Submission No.	117
Organisation Name or Name of Submitter	Hines Real Estate Ireland Limited (represented by Waterman Moylan)

Re : Railway (Metrolink-Estuary to Charlemont via Dublin Airport) Order 2022, AerCap House (former 65-68 St. Stephens Green)

Drawing Title	TUNNEL ALIGNMENT SAINT STEPHEN'S GREEN – CHARLEMONT RO APPLICATION VS DEEPER VERTICAL ALIGNMENT OPTION	Drawing Status	S4
Drawing N°	ML1-JAI-RTA-ROUT_XX-DR-Y-02027		
Scales Original Size A1	1 : 1000	Sheet	01 of 01

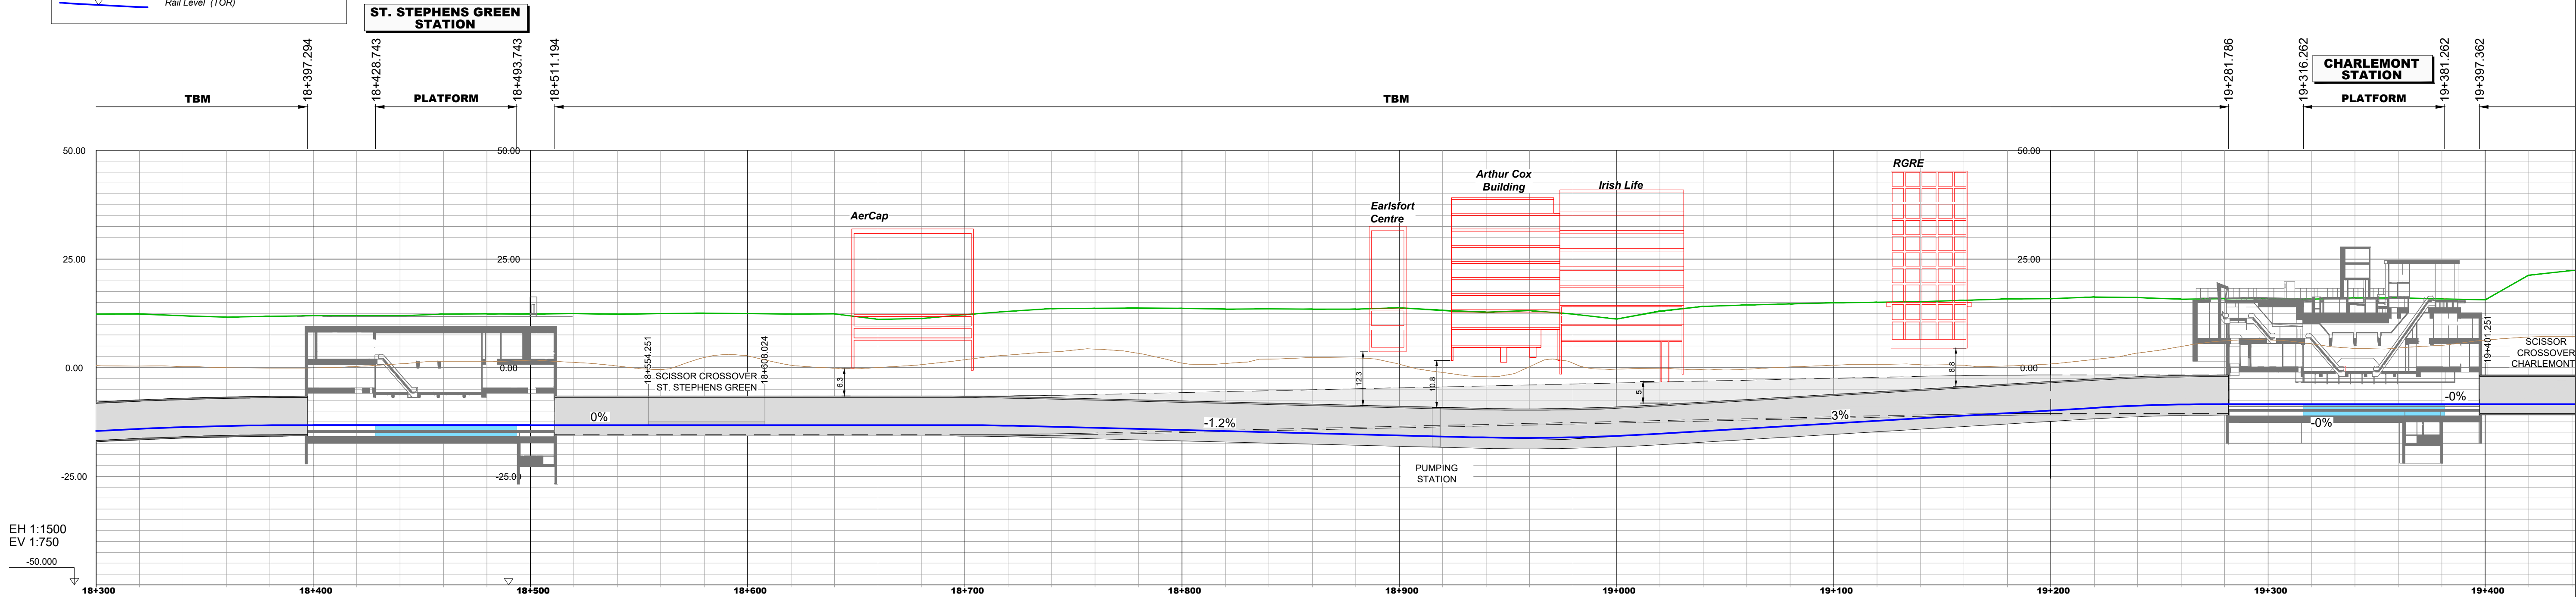
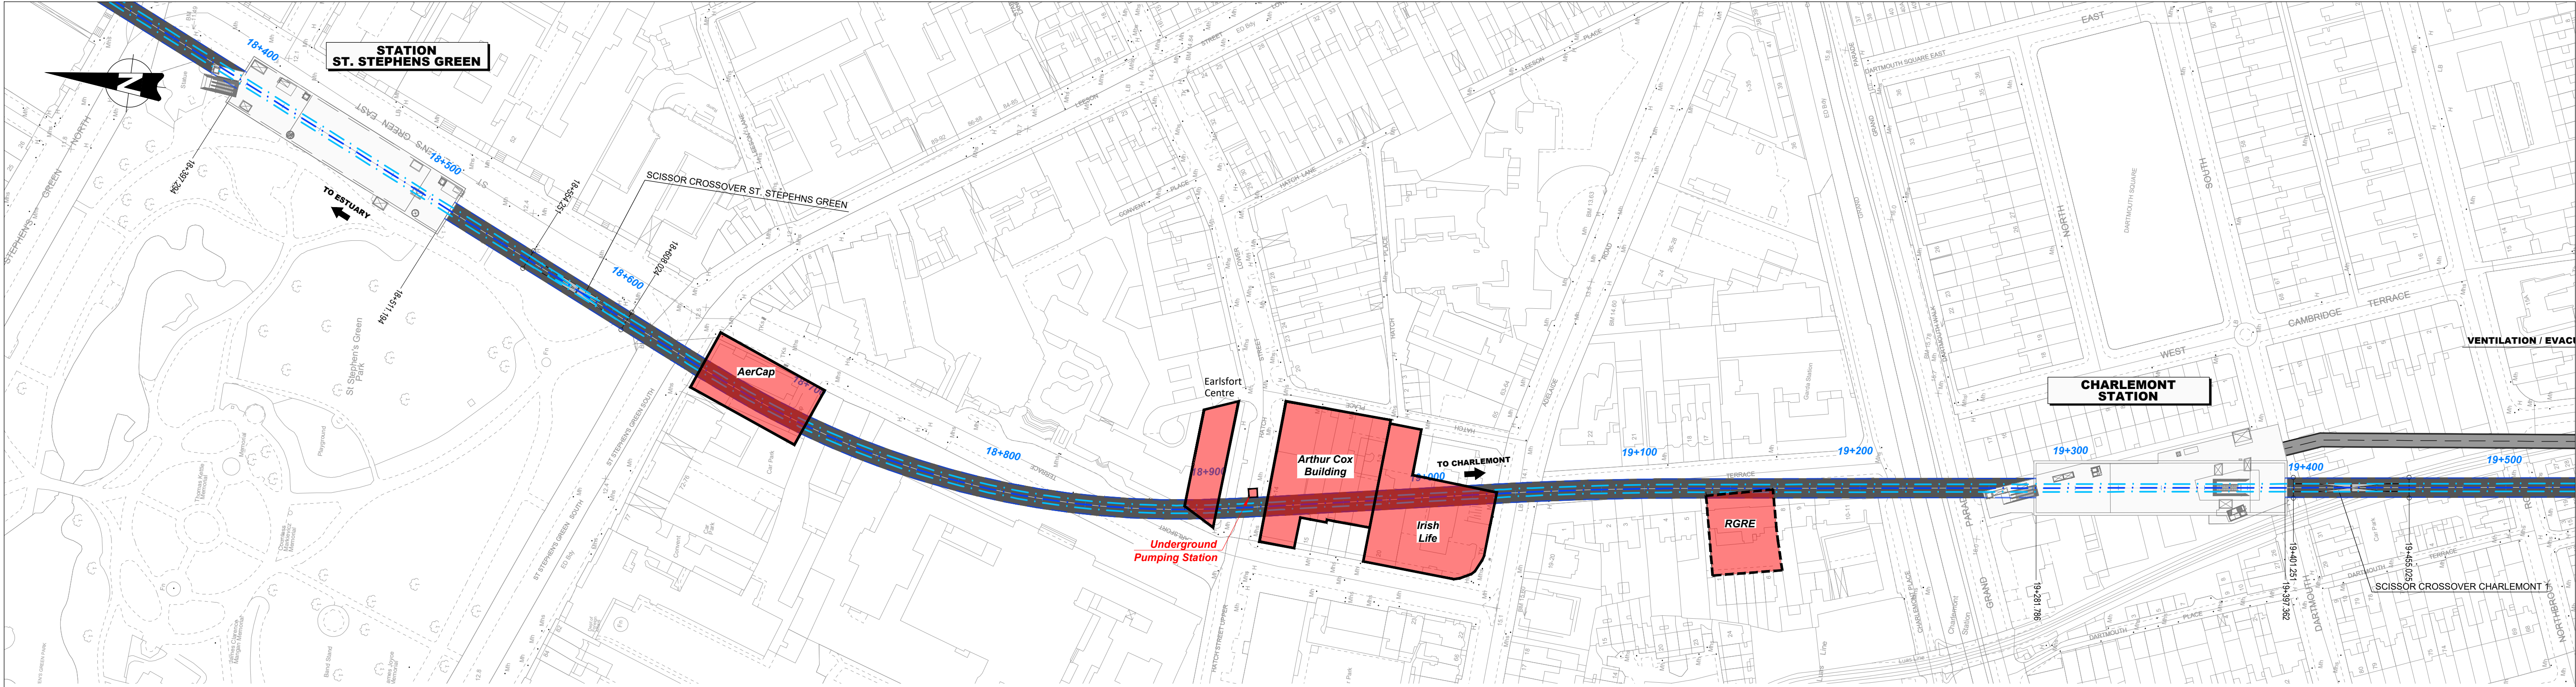
6	Summary	4	In summary, our client requests that the route of the proposed MetroLink tunnels are diverted away from their current proposed location (under our client's building) to either below the public carriageway or buildings that will not be damaged or compromised by the presence of the tunnels located under.	<p>TII do not intend to alter the alignment as the building damage assessments undertaken support the validity of the alignment. Refer to Item 1 above.</p> <p>The proposed vertical alignment has already been determined to provide sufficient rock cover to the tunnel and therefore to limit the ground movement impact on the building above to a sufficiently low level.</p>
